Section 96A of the Town and Country Planning Act 1990

Non-material amendment application – 23/00354/FUL- Erection of 2no. detached dwellings with associated access, parking and landscaping following demolition of existing dwelling and garage.

Site: Streathfield, Shoreham Road, Otford

0 PLAN
PLOT A - GROUND FLOOR SCALE 1: 100

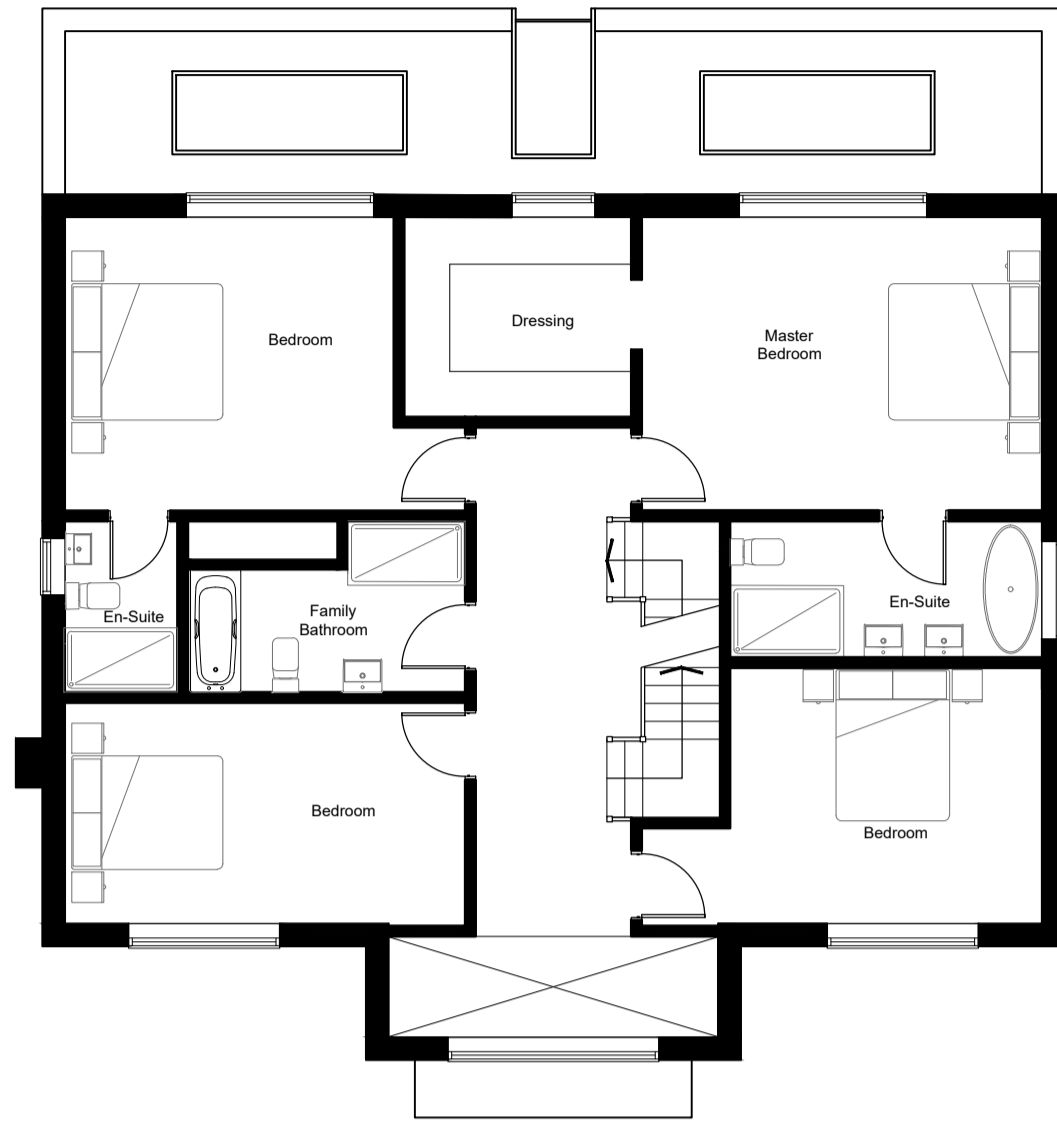
The changes to the ground floor window and door would not result in any greater impact on the amenity of neighbouring residents, or cause harm to future occupants of either approved dwelling. A comparison between the as approved and as now proposed is shown below to highlight the insignificant nature of this non-material amendment.

DRAWING TITLE
**PROPOSED PLANS &
ELEVATIONS (PLOT A)**

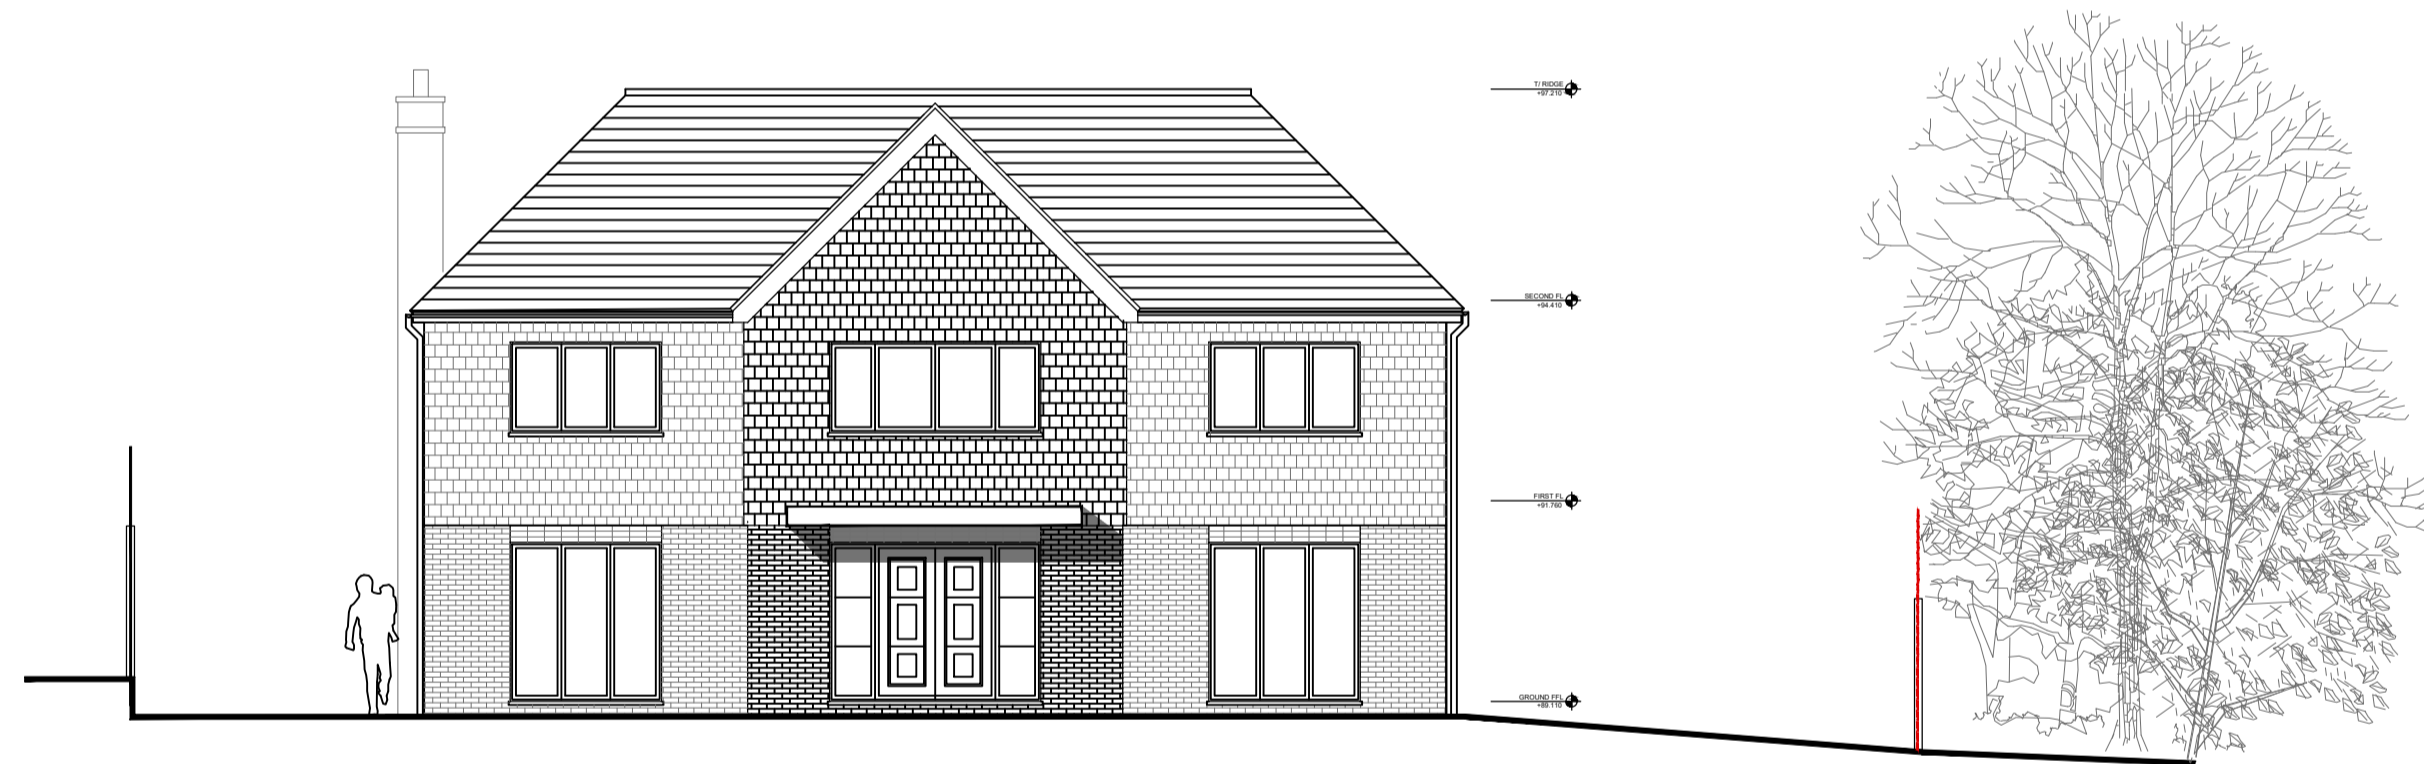
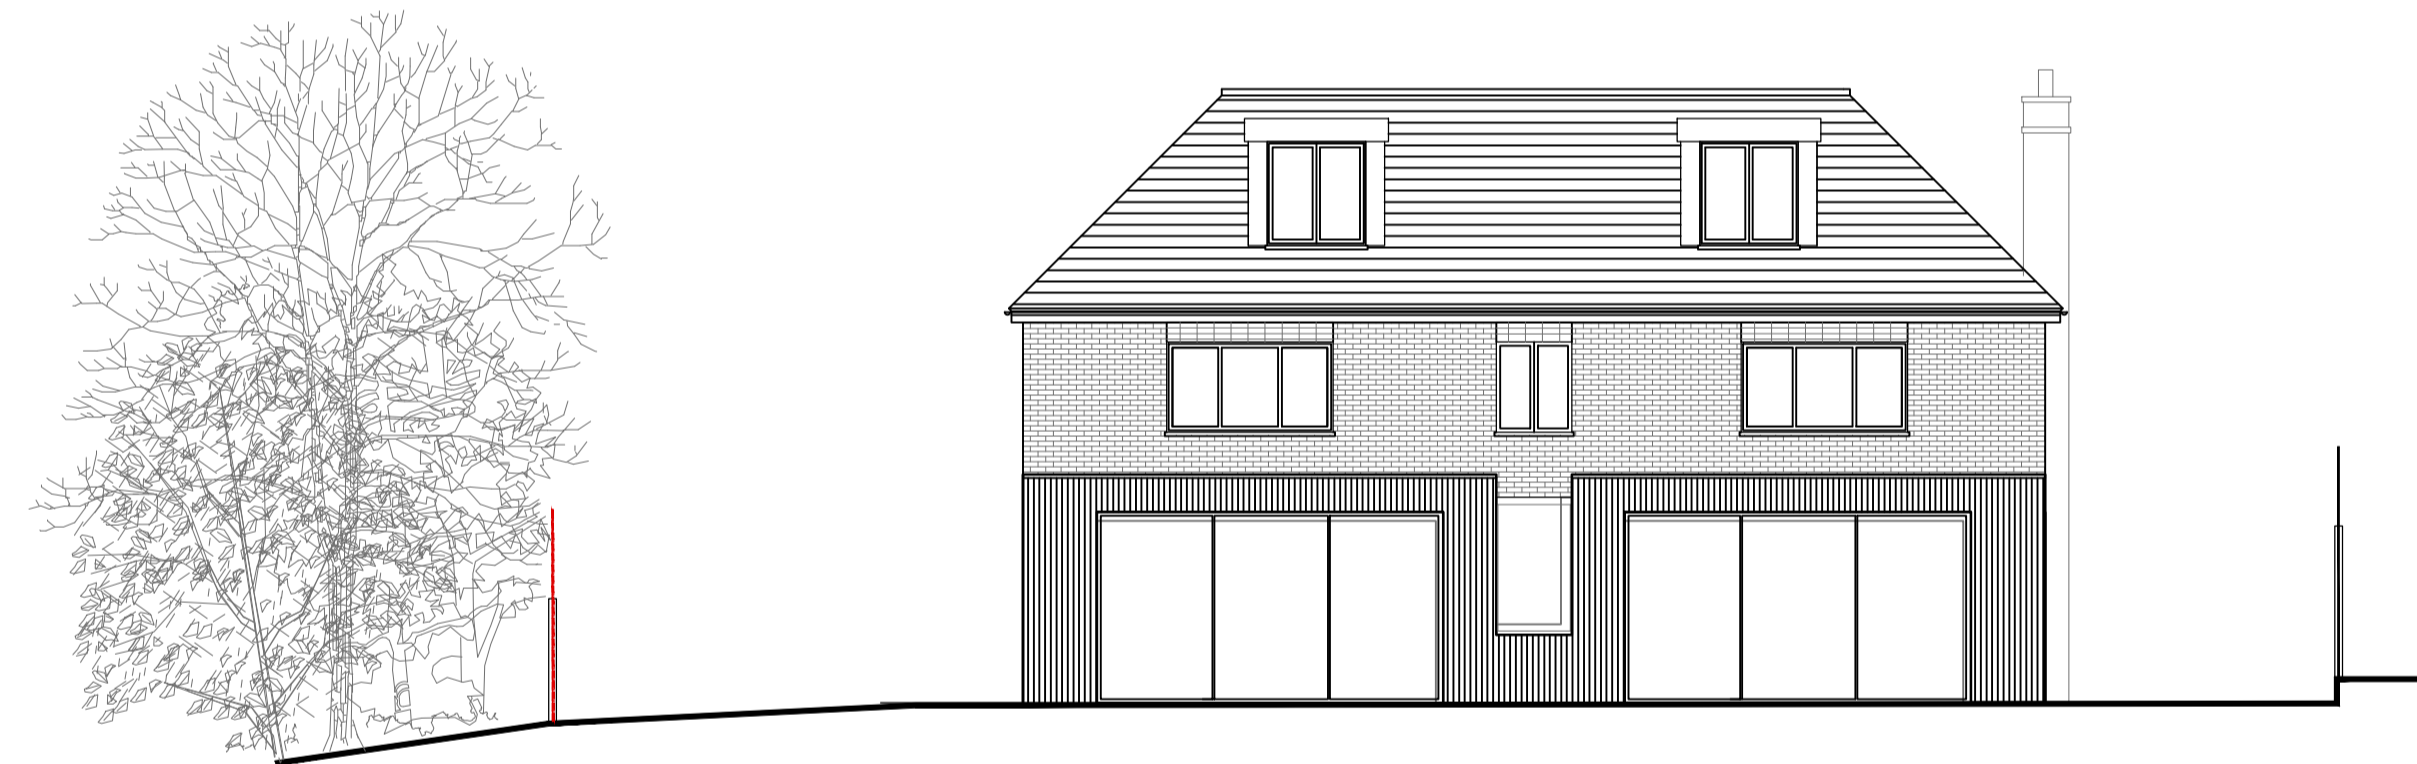
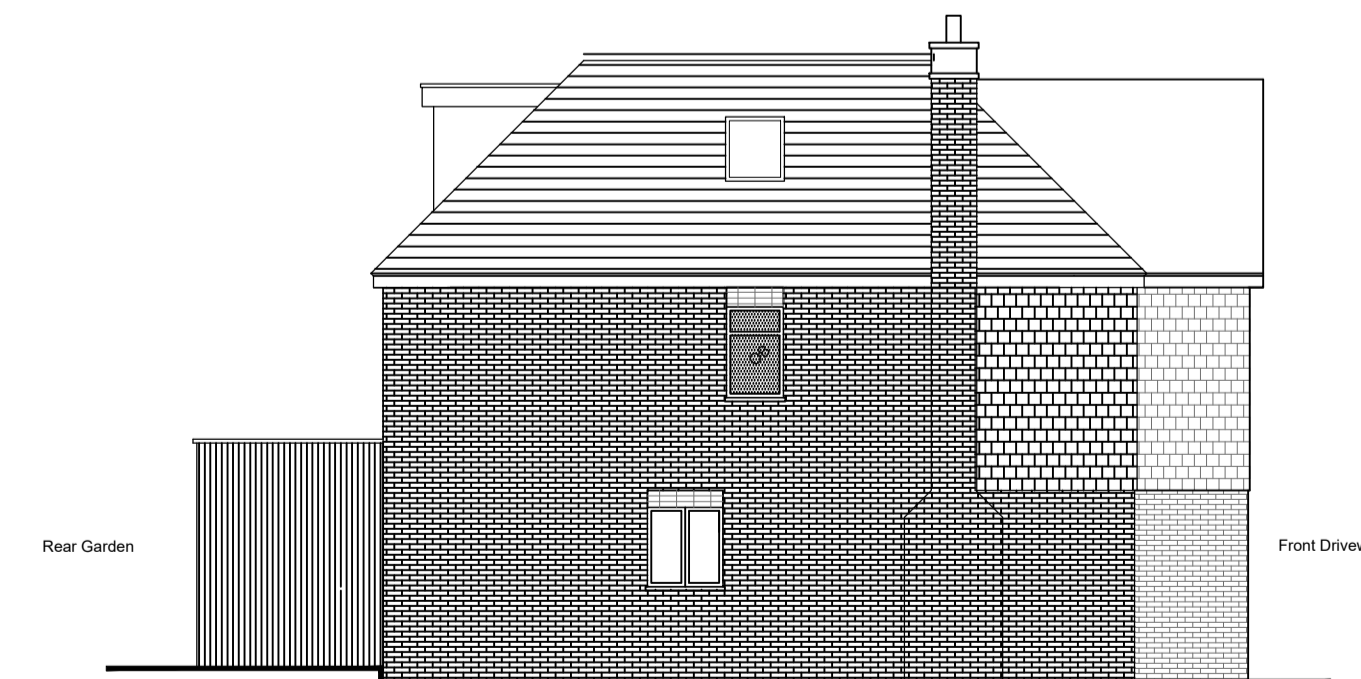
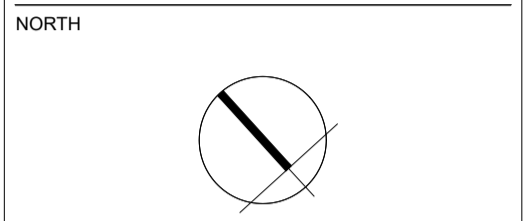
The non-material amendments result in minor changes to the approved elevations of Plot A only and include swapping the chimney from the south elevation to the north elevation and changes to the window and door arrangement at ground floor only (flank elevations). These very minor changes are a result of changes to the internal layout at ground floor.

The non-material amendments involve swapping the approved chimney on Plot A from the southern elevation to the northern elevation. The design/scale of the chimney remains as approved. Below the as approved and as proposed front elevation is shown for comparison purposes.
